Re: Planning Application Ref 38718/APP/2021/4389- No 11 Thornhill Road

It is noted that following submission of the above planning application, three letters containing comments have been received from occupiers of neighbouring properties. Accordingly, this letter sets out a full written response to all planning issues raised within these comments to assist you in your determination of the application.

Site Plan - Ground floor & First Floor Plans

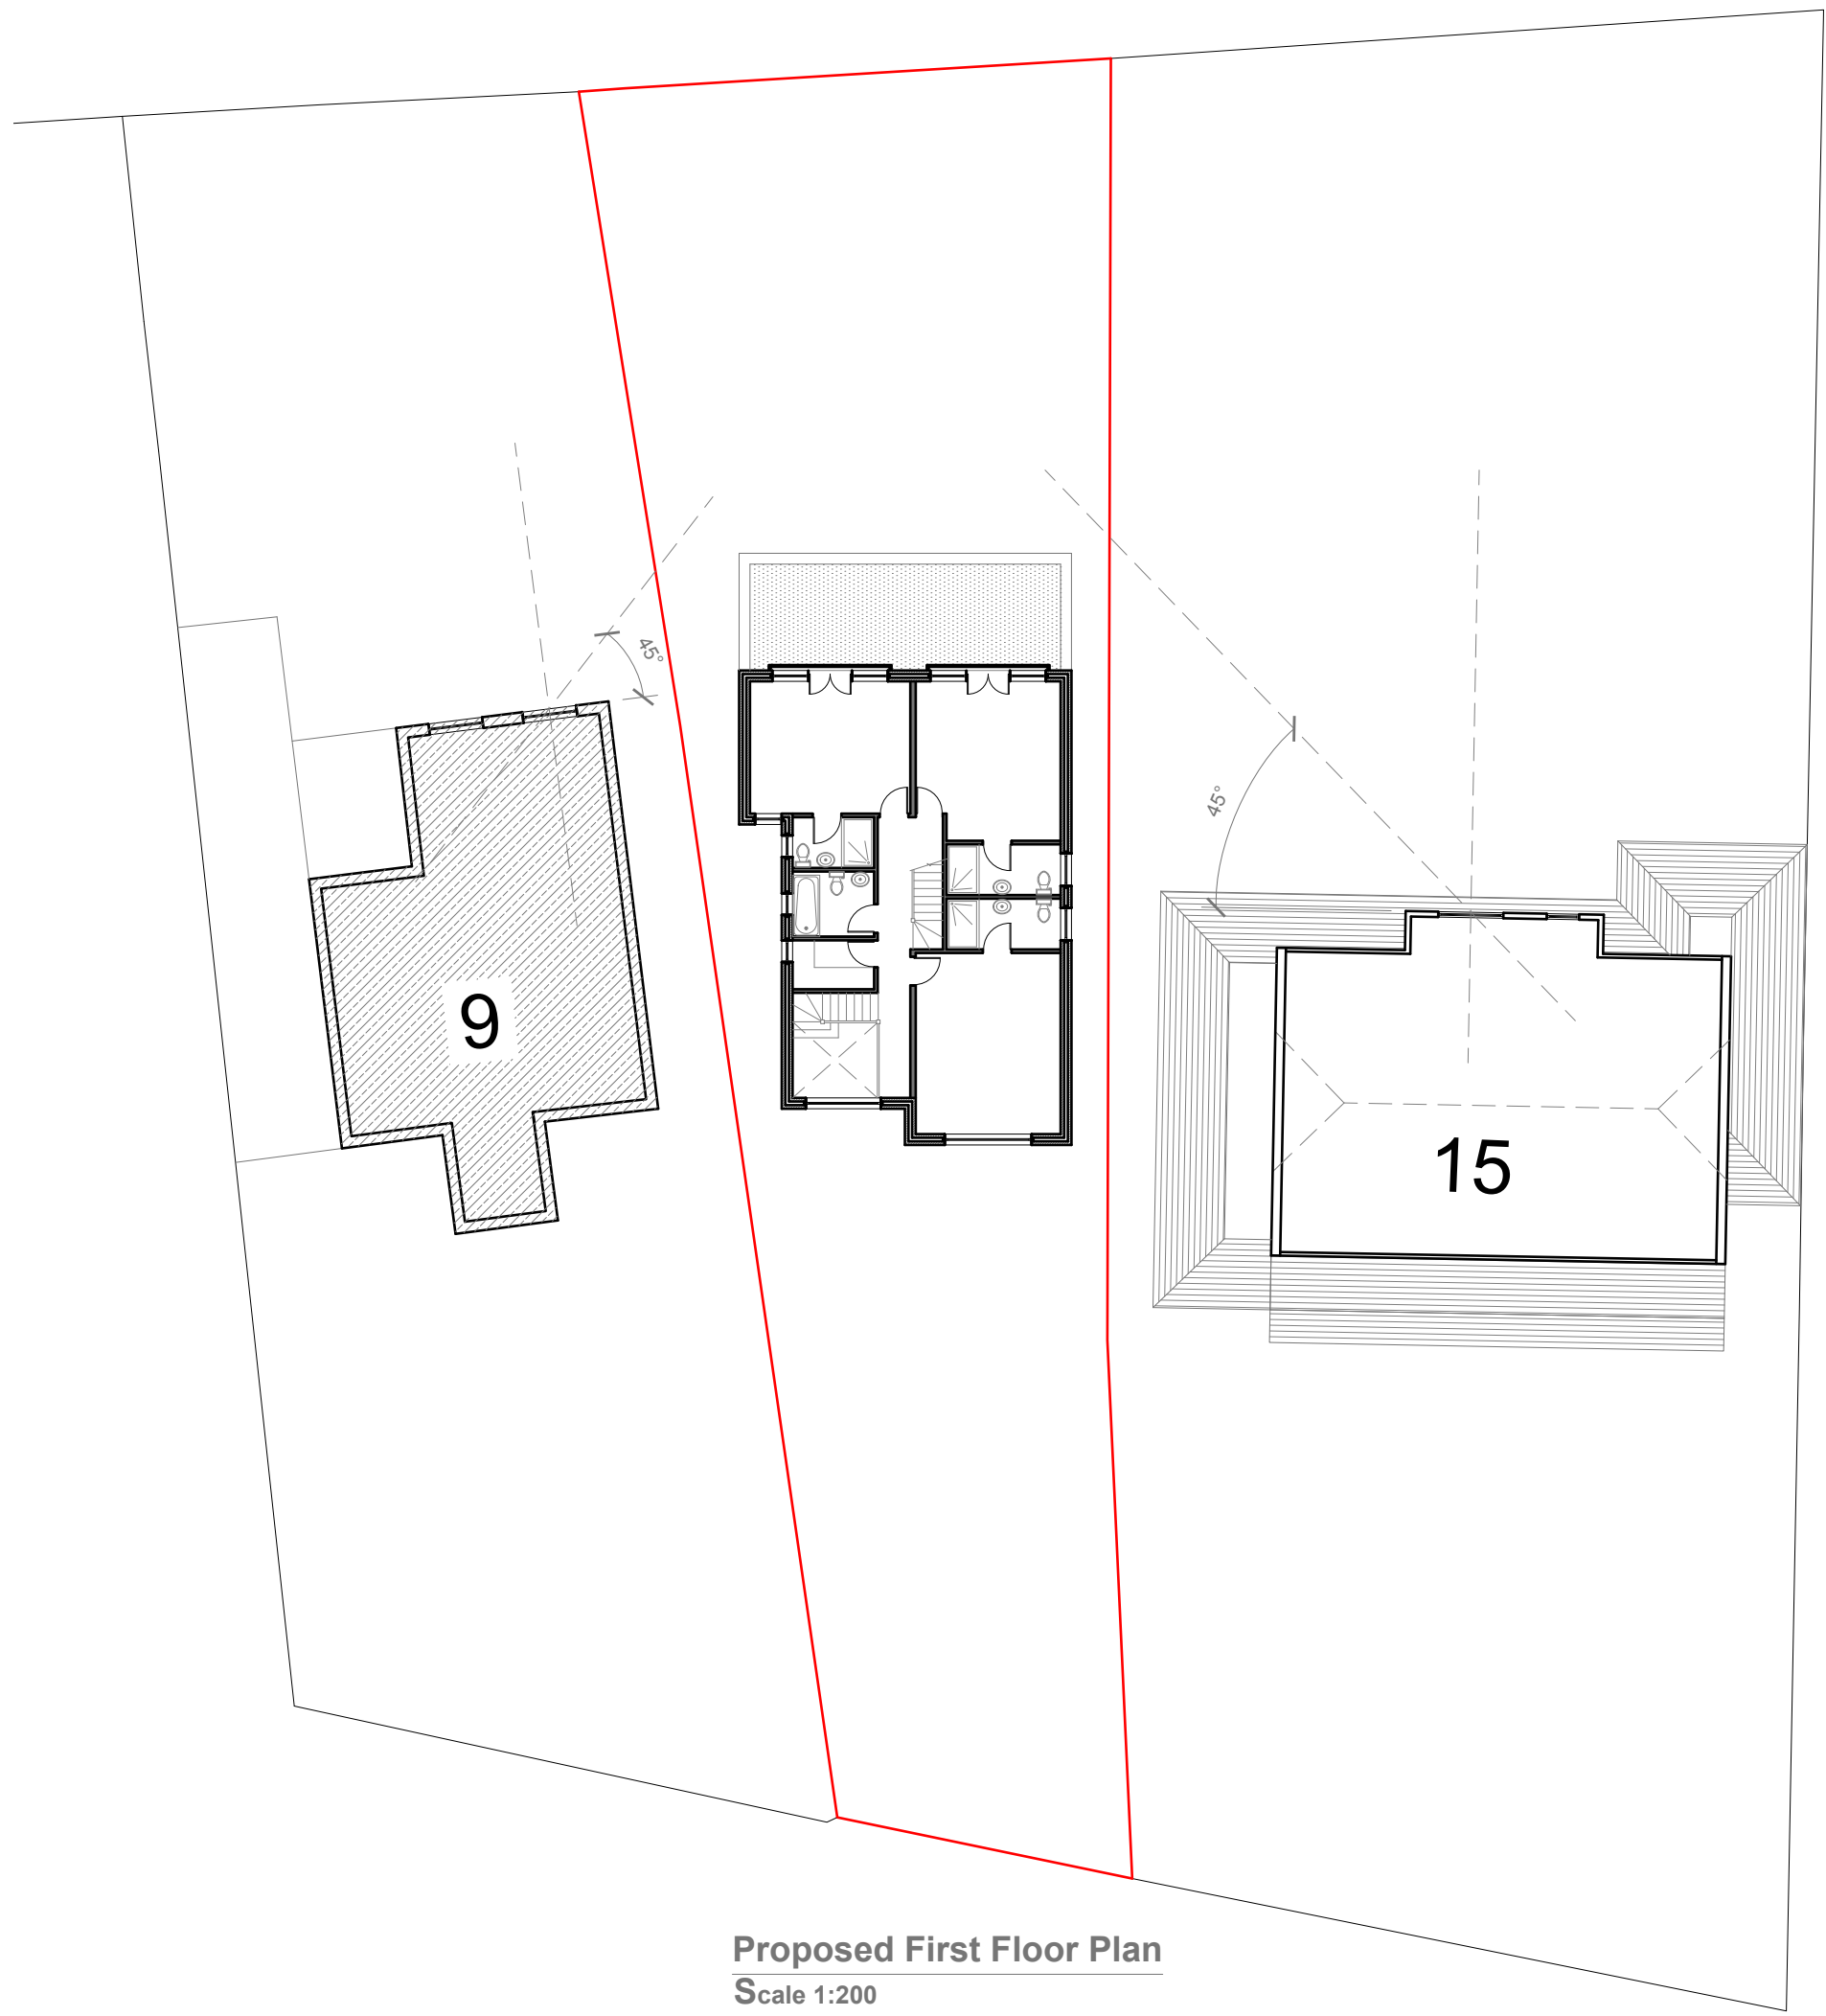
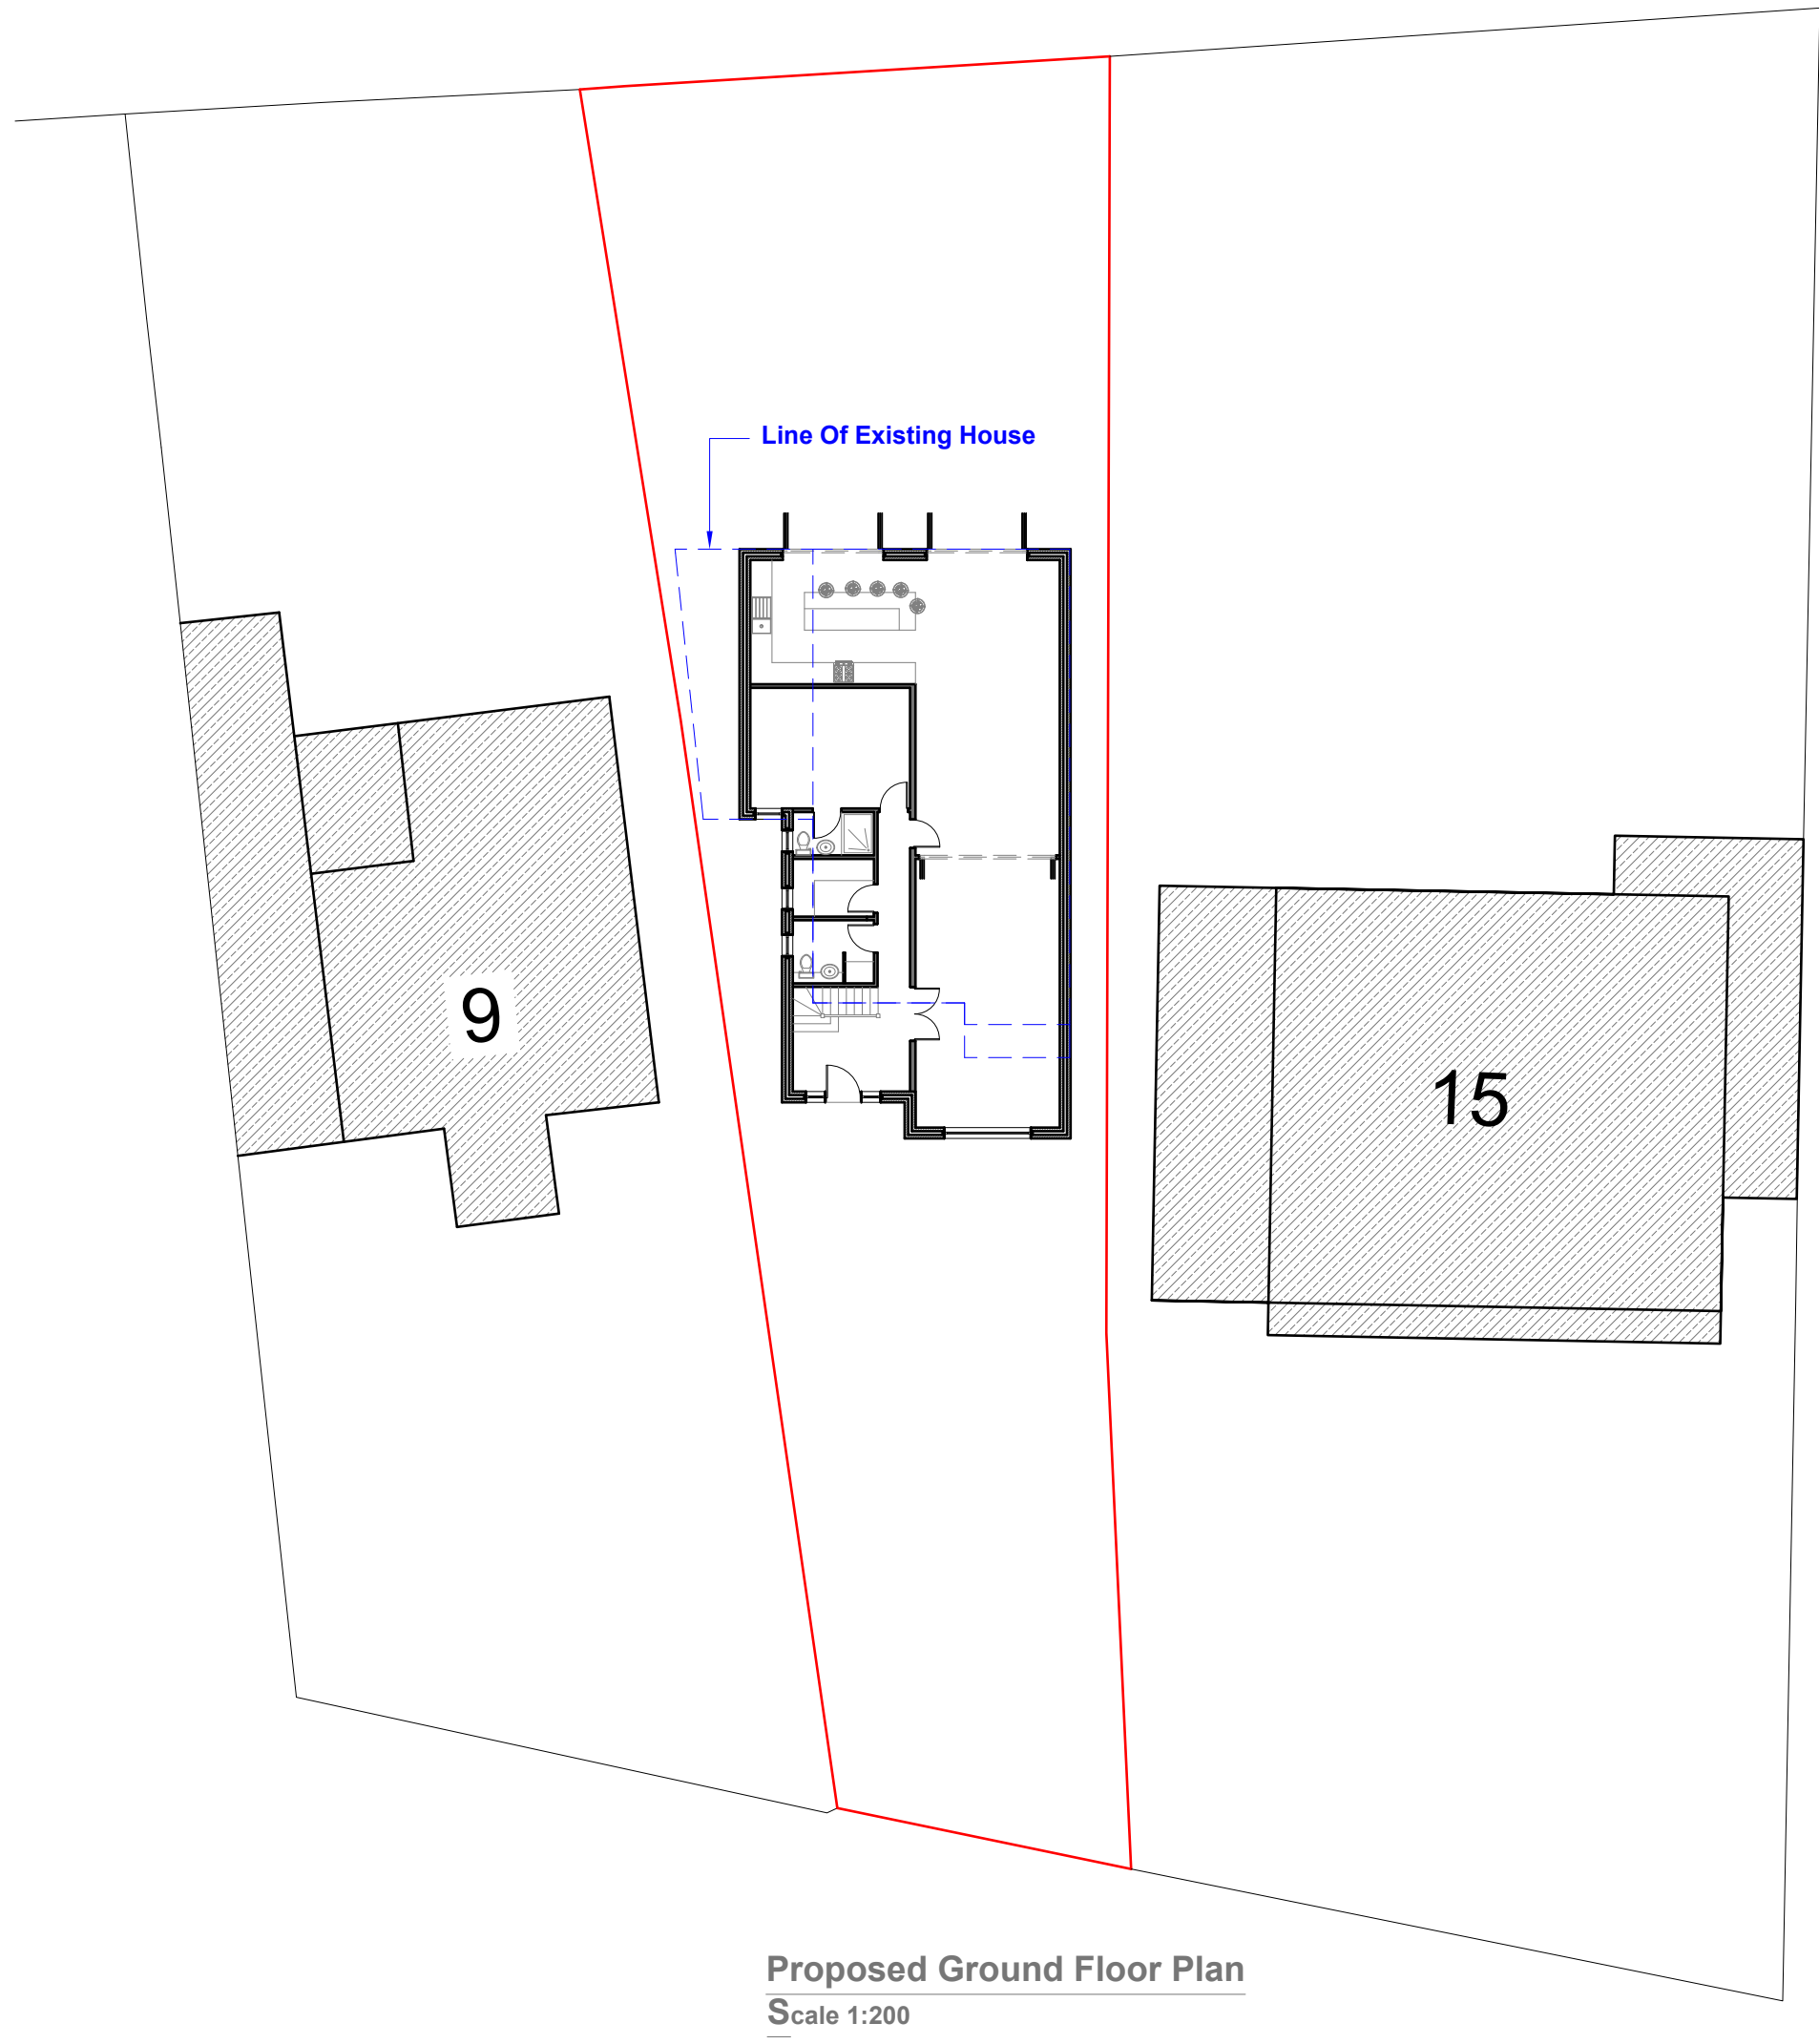
"The proposed plan of the new two storey structure would block sunlight into my garden and back kitchen/diner in the afternoon and evening and the front garden in the morning. The upstairs would look into the garden and stop any privacy. The upstairs would also overlook the front garden and drive. This would cause a loss of light and privacy to our home. The demolition of the garage will remove a wall between our houses and could cause a movement of ground."

As confirmed by the proposed site plans which formed part of the submitted drawings package (enclosed at **Appendix 1** for your ease) the proposed dwellinghouse will maintain broadly maintain the footprint of the existing dwellinghouse at ground floor level. Whilst additional massing is proposed at first floor level this has been carefully considered to be set back by approximately 3.2 metres from the ground floor rear elevation. Thereby, allowing the proposed dwelling to broadly maintain the same building line as No 9 Thornhill Road to the north at first floor level.

Furthermore, as also demonstrated on the proposed site plans clear 45 degree views will be maintained from habitable windows of all neighbouring properties. As such, it is not considered there will be any impact on amenity of neighbouring properties by way of overlooking, loss of light or privacy.
